CITY OF PORTLAND BUILDING PERMIT

PERMIT ID: 2013-00333 **ISSUE DATE:** 04/11/2013 **CBL:** 131 H011001

has permission to **Create One Handicap Family unit - removing 2nd kitchen facilities & add new deck**

Proposed Use: Change of Use from two family to Single Handicap Family Unit (no more than 16 beds)	Proposed Project Description: Create One Handicap Family unit - removing 2nd kitchen facilities & add new deck
-------------------------------------------------------------------------------------------------------------	--------------------------------------------------------------------------------------------------------------------------

SPRINKLER SYSTEM NOTES

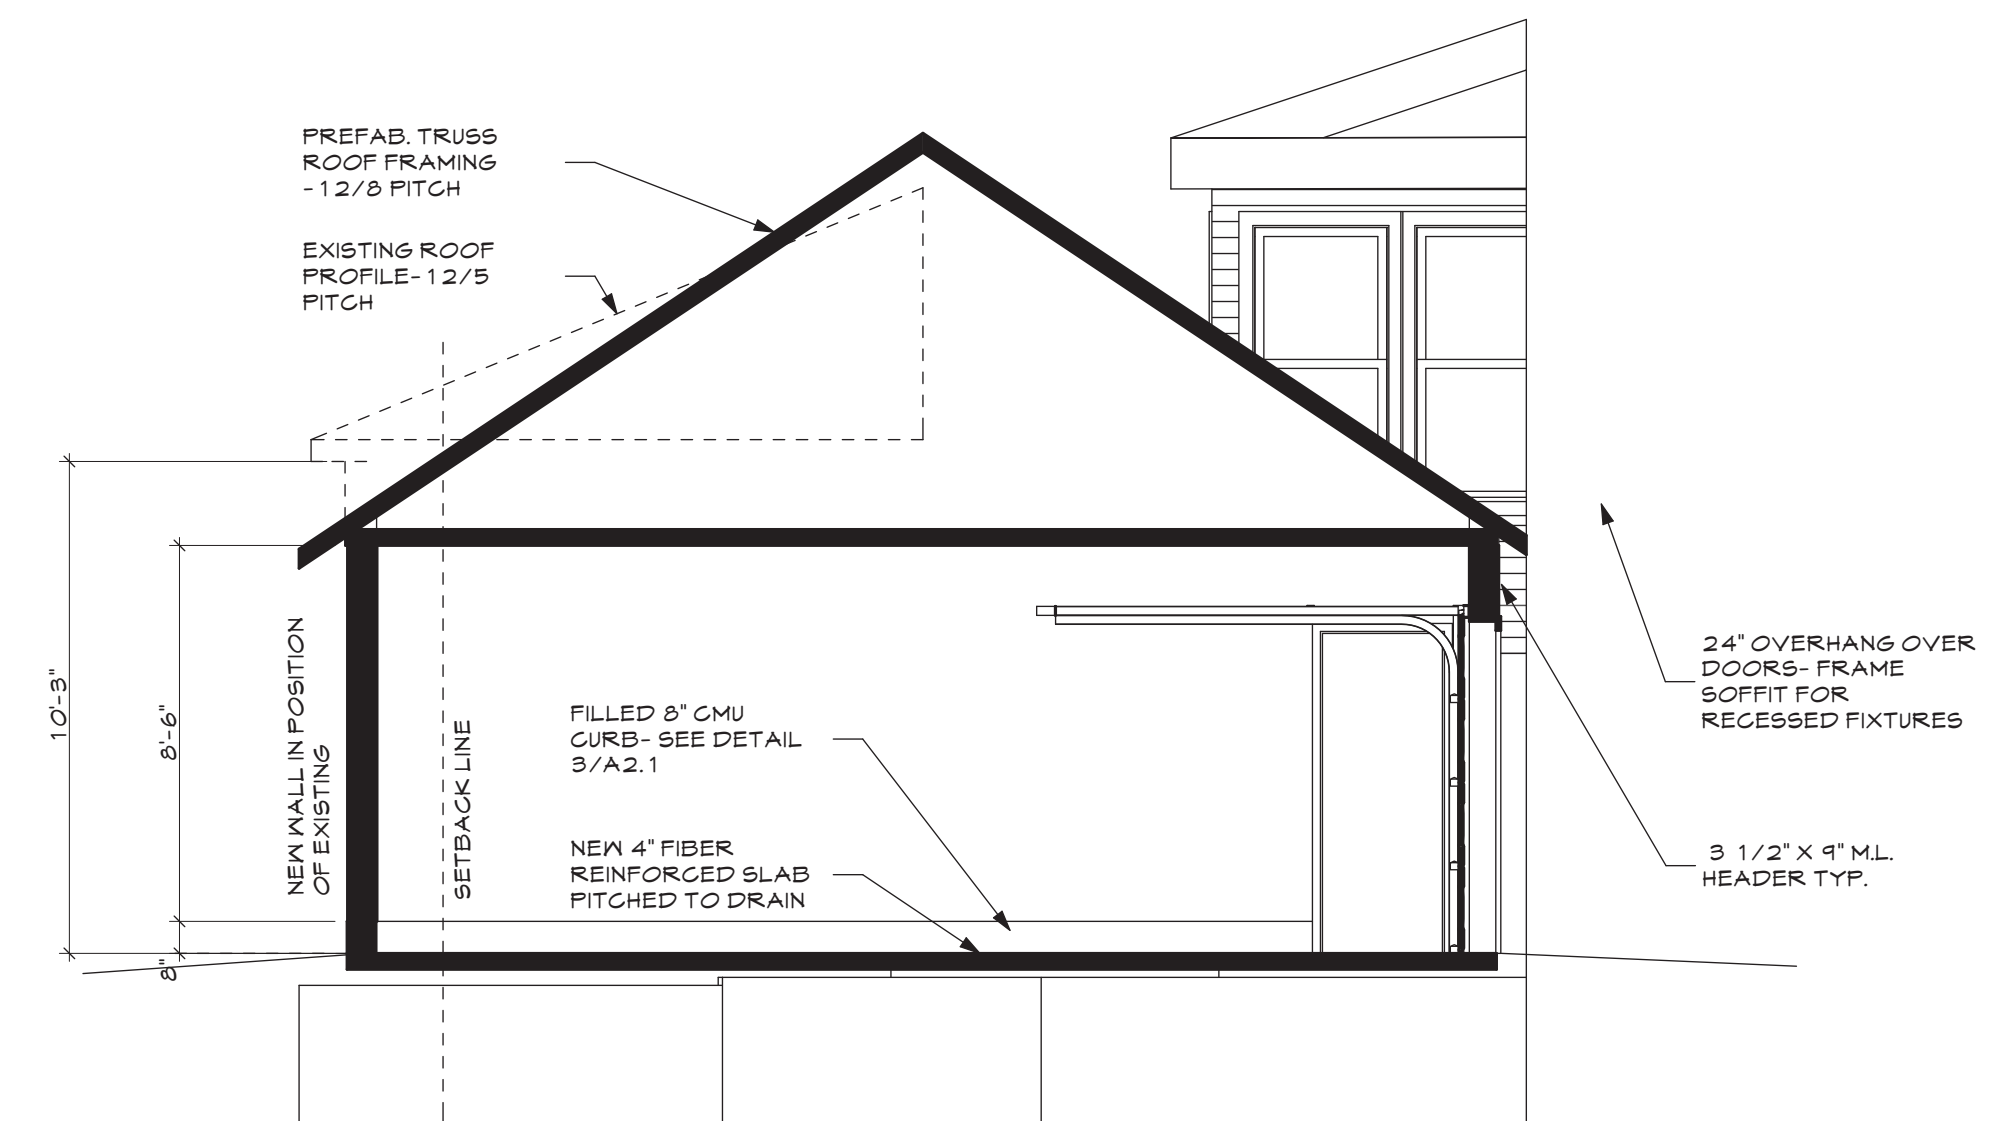
A3.1

Define Grade Plain vs Level

Framing Detail for wall additions

Explain use of Attic
